Planning Officer: Mr A Wood

Planning Application Ref: EP/67/20/PL

Location: Land adjacent to 45 The Ridings, East Preston, BN16 2TW

Description of works: 1No. detached house & formation of associated new access

APPENDIX 2 – Tree Protection Plan

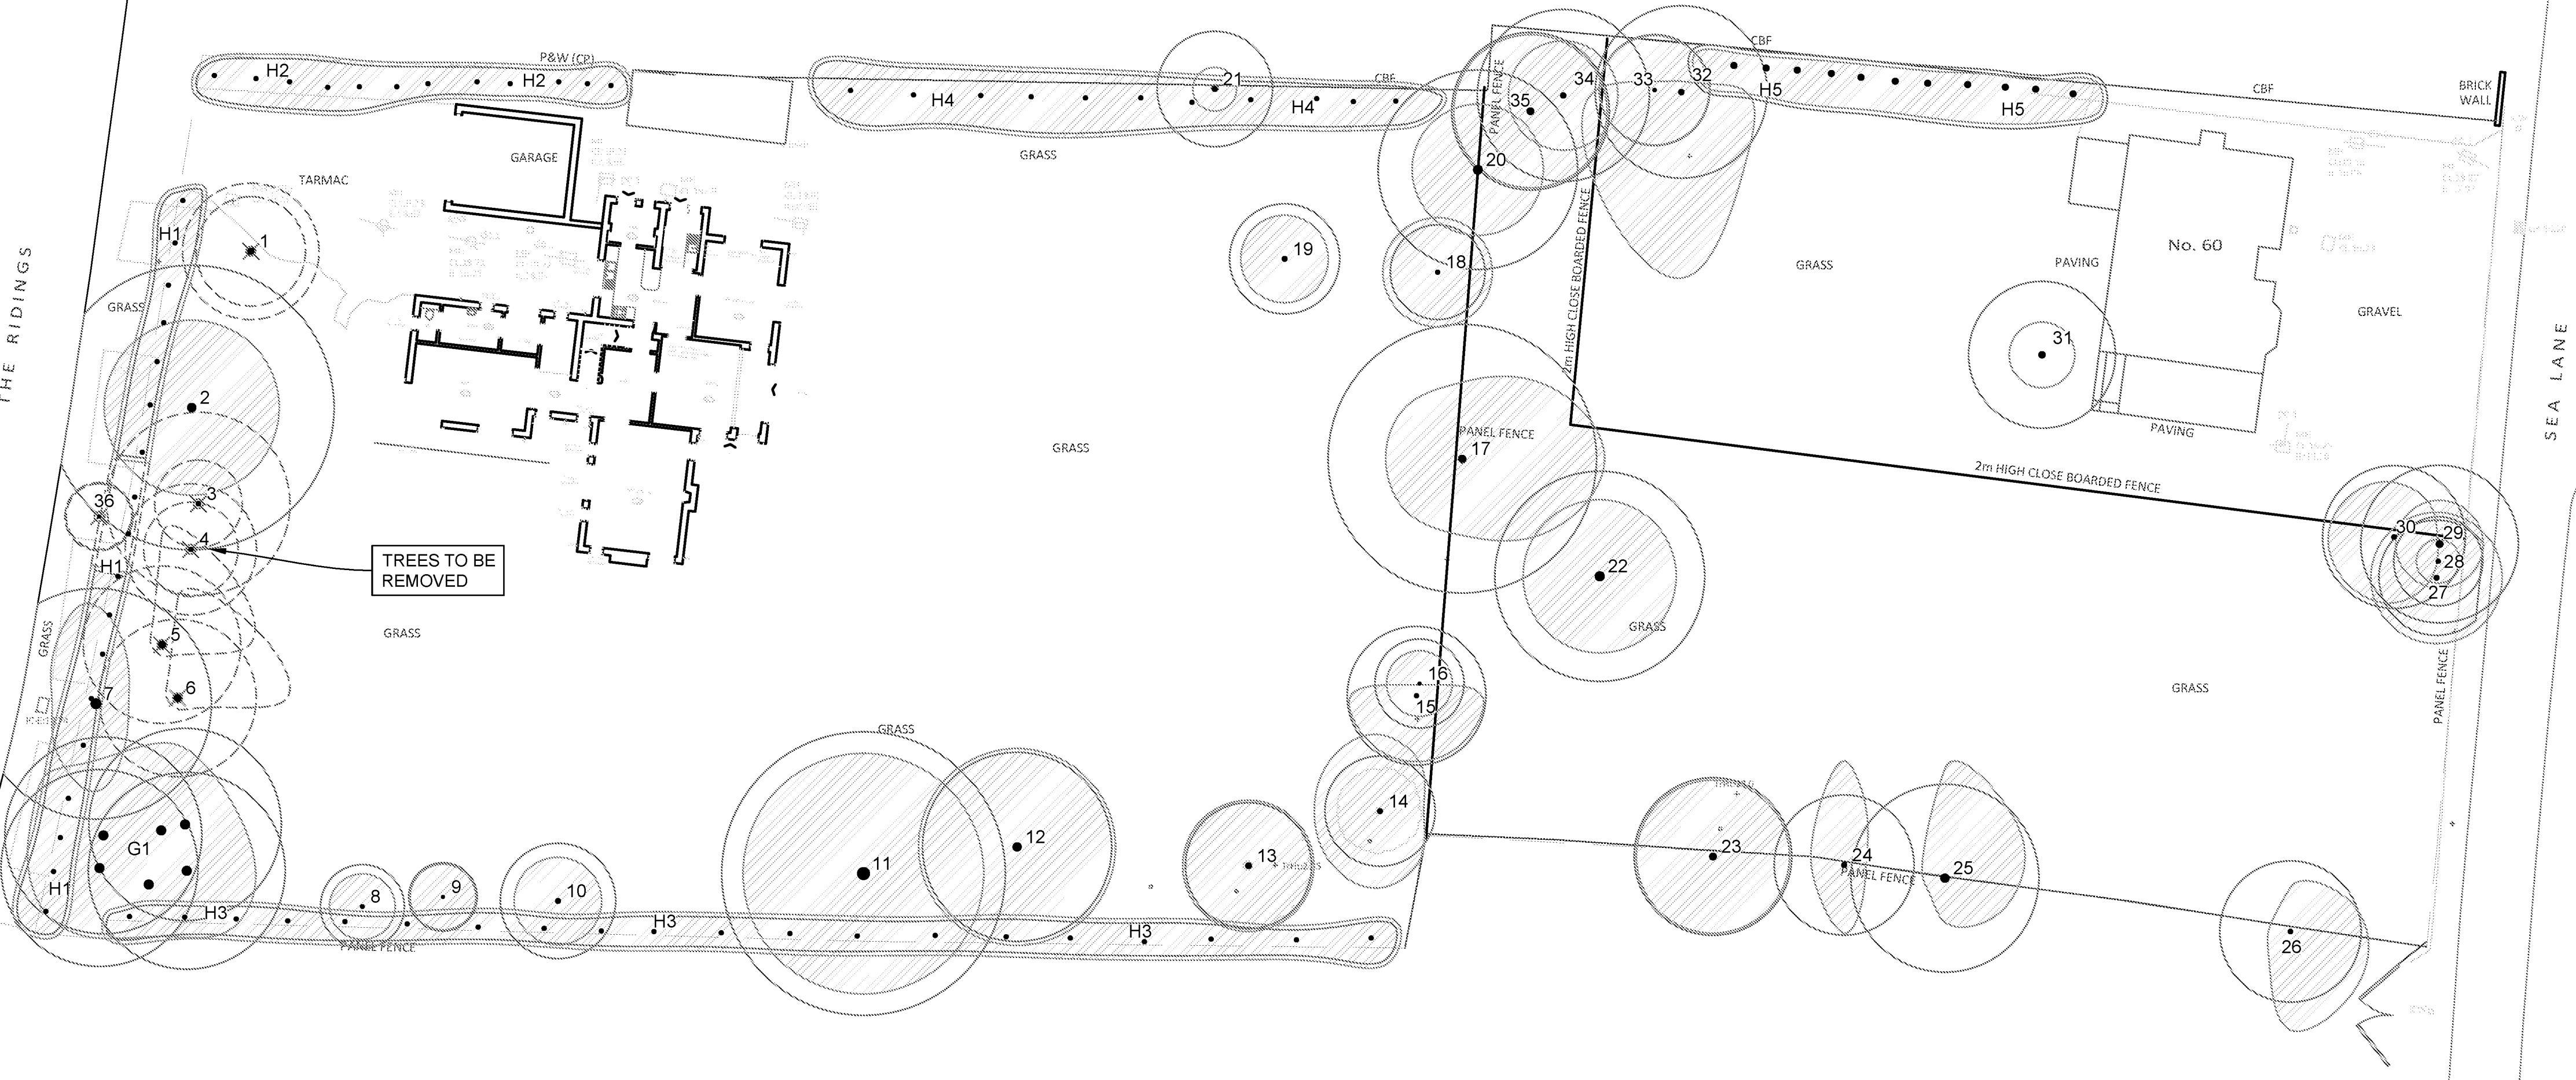
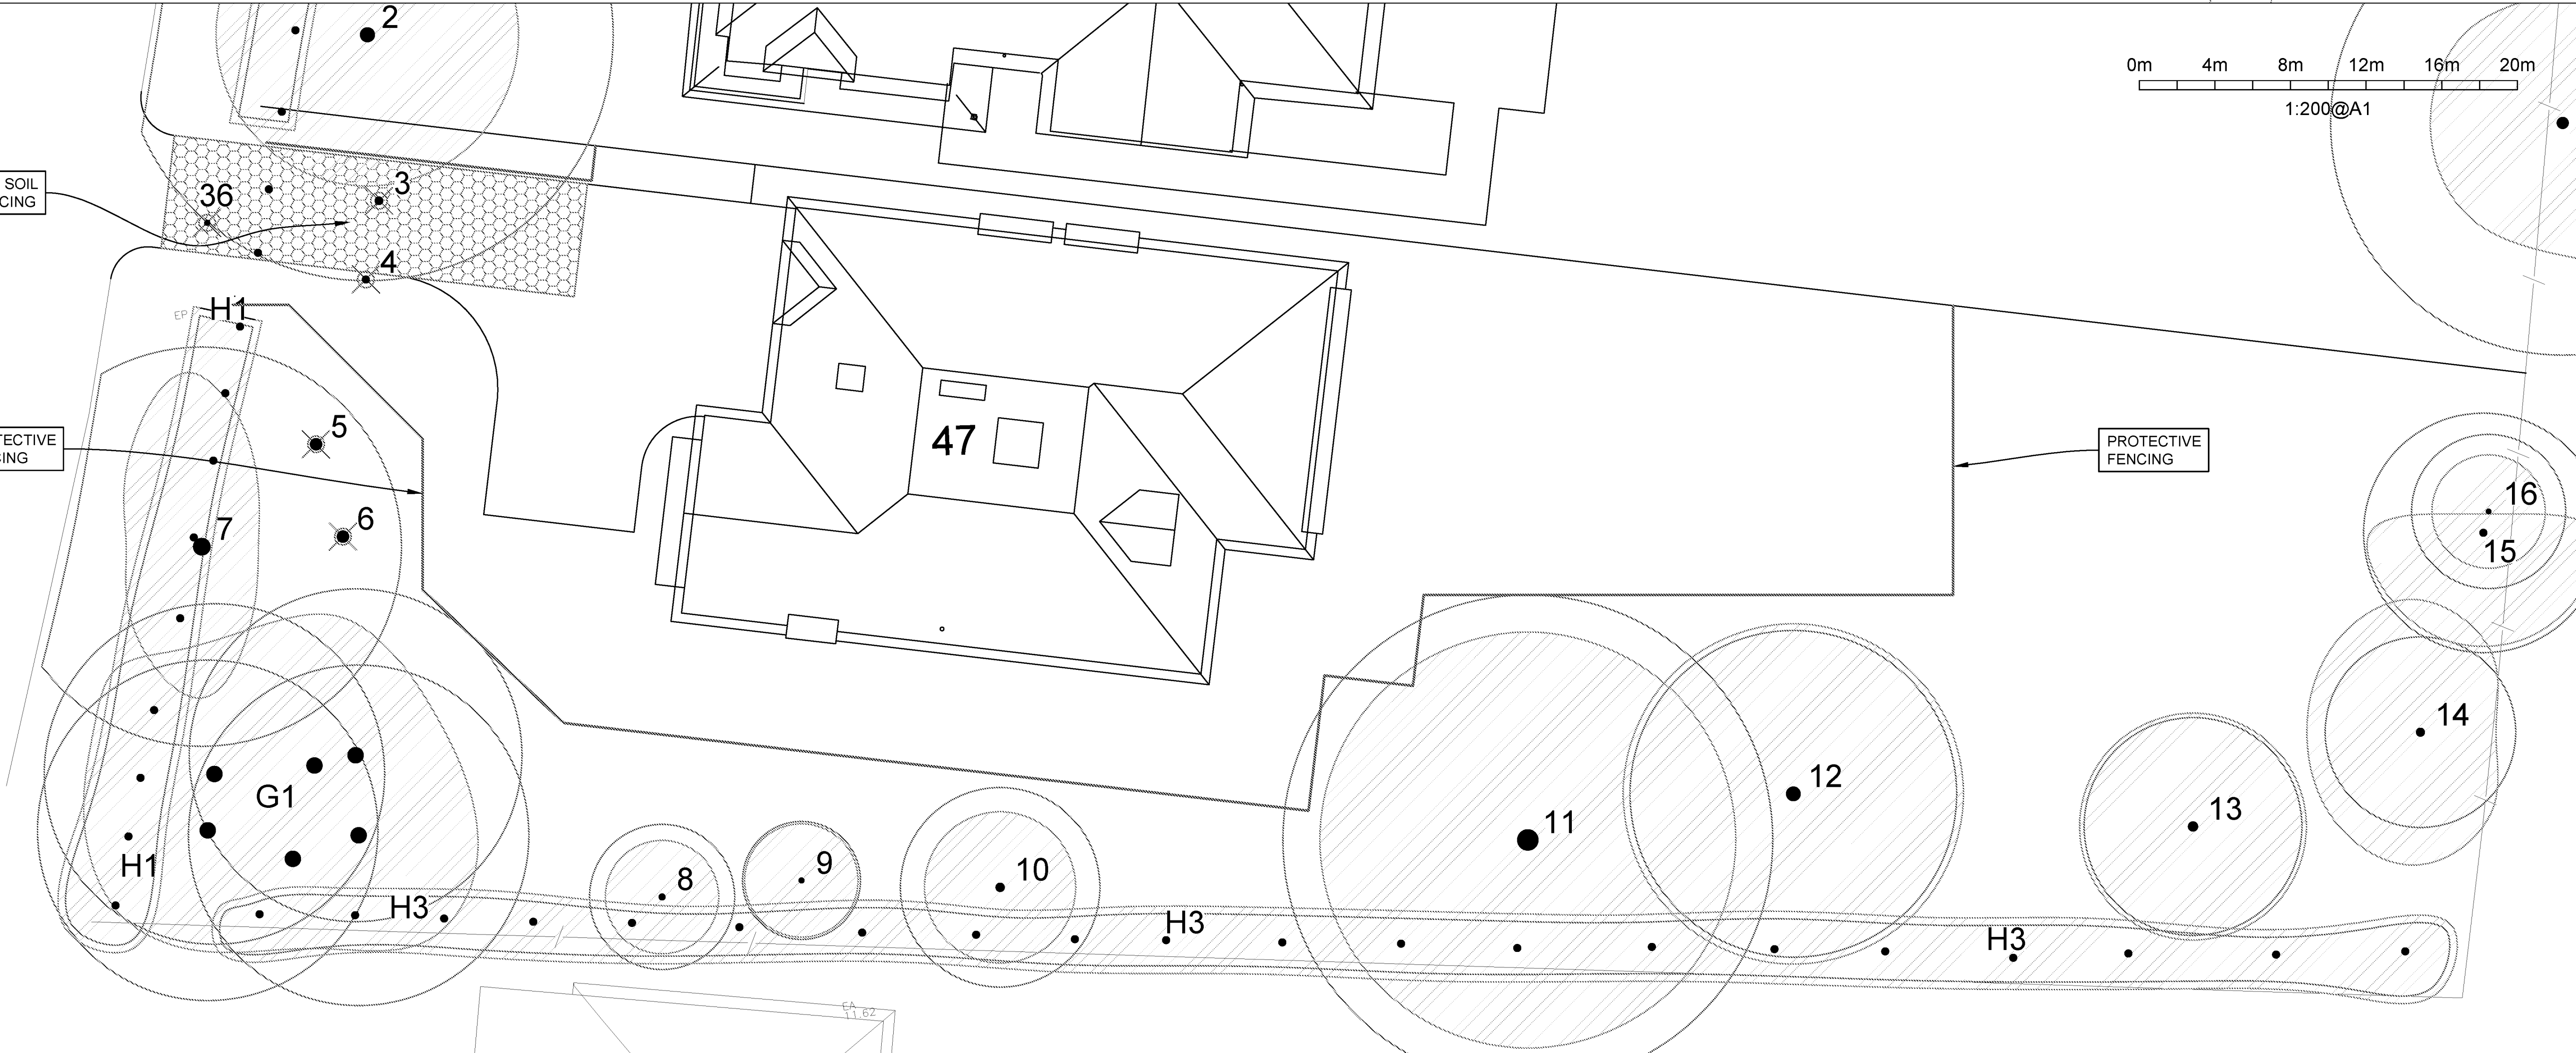
- I have considered this application by means of a desktop review, using the information and plans submitted as well as online resources.
- The applicants have employed David Archer Associates to prepare an Arboricultural Method Statement along with a Tree Protection Plan for this project.
- The supporting Tree Survey data is comprehensive and accords with the requirements of BS5837:2012.
- Although some tree loss is proposed to facilitate access onto the site, those individuals are of relatively low quality and those of higher quality fronting the site are to be adequately protected.
- Drainage and service-runs in and out of site have not been shown and so there remains a possibility of further root protection area incursion to satisfy those requirements.

- The principle of development as described is achievable without undue detriment to retained trees, provided there is adequate site supervision at key stages by the project arboriculturist.
- Trees of lesser quality and landscape value are (and will inevitably have) to be sacrificed to provide the least visually detrimental access onto the plot.

- I recommend the above scheme for **APPROVAL**, subject to the following conditions being applied:
 1. Before the site is occupied or any machinery is introduced to the site or demolition work or construction work or alterations to existing ground levels takes place a **PRE-COMMENCEMENT Site Meeting** is to take place between the Planning Authority's Tree Officer and the Arboricultural Expert representing the site owner(s) – at this meeting all protective fencing will be inspected to verify it is 'Fit for Purpose' as required under British Standard 5837:2012 and have been erected and positioned exactly as shown on the **Tree Protection Plan, dwg. no. TPP 03, Sept. 2016**.
